From: [REDACTED]
Sent: 21 April 2025 18:30
To: Planning
Subject: Comments regarding Planning ApplicationNo. 3/2025/0226

Planning Application No. 3/2025/0226

Site Address: Lane Ends Farmhouse, Nightfield Lane Balderstone

Ground Floor Plan

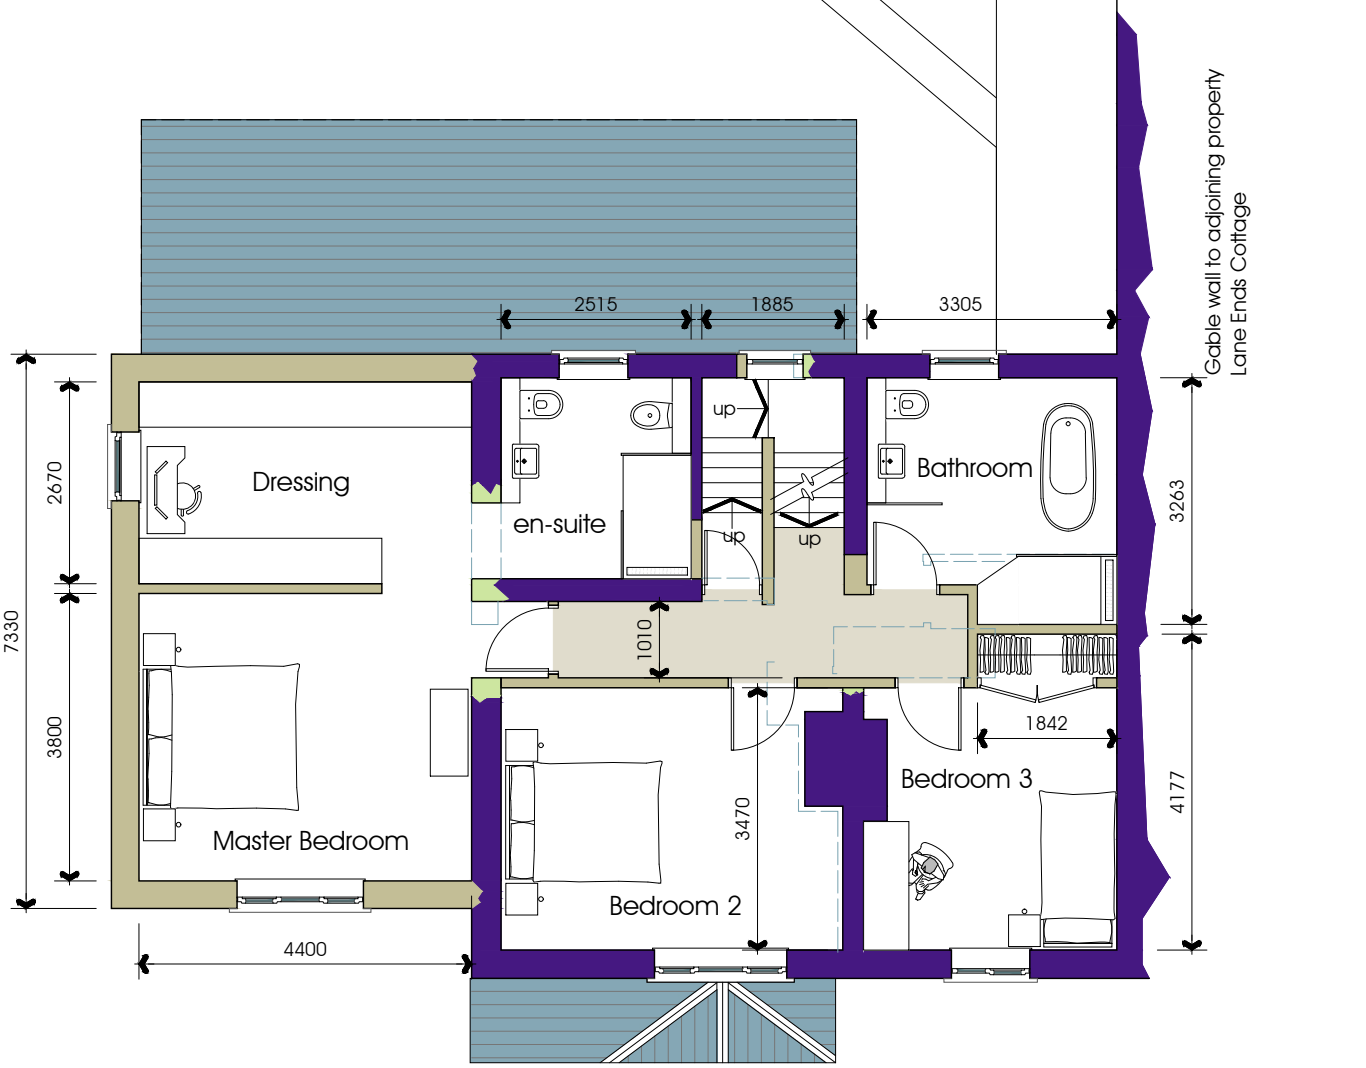
[REDACTED] - On the original plan it does not show the existing gate and wall that has [REDACTED]. This wall is not shown on the new plan either so we assume that this will be removed. There is also water tap/hose mounted [REDACTED].

The new drawing shows a fence and gate positioned [REDACTED].

North East Elevation

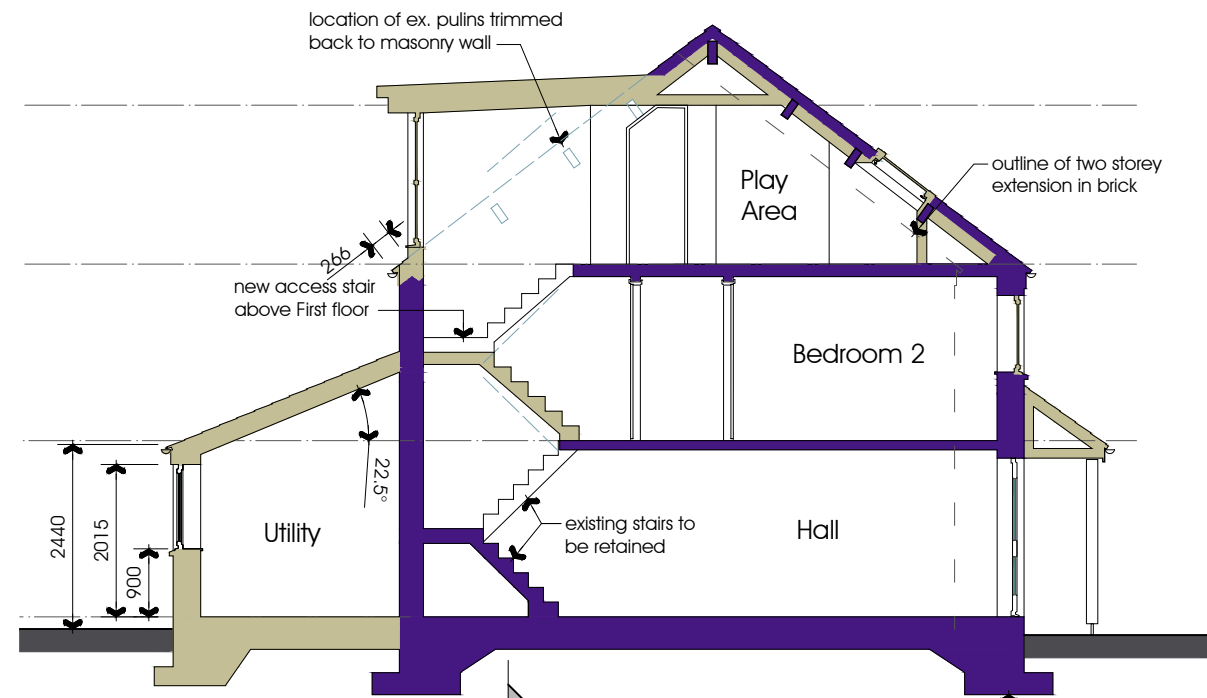
Upper window on the east elevation - A window at that level has clear [REDACTED]. This will impact our privacy. If plans are passed, can it be ensured that the overlooking window is of obscure glass.
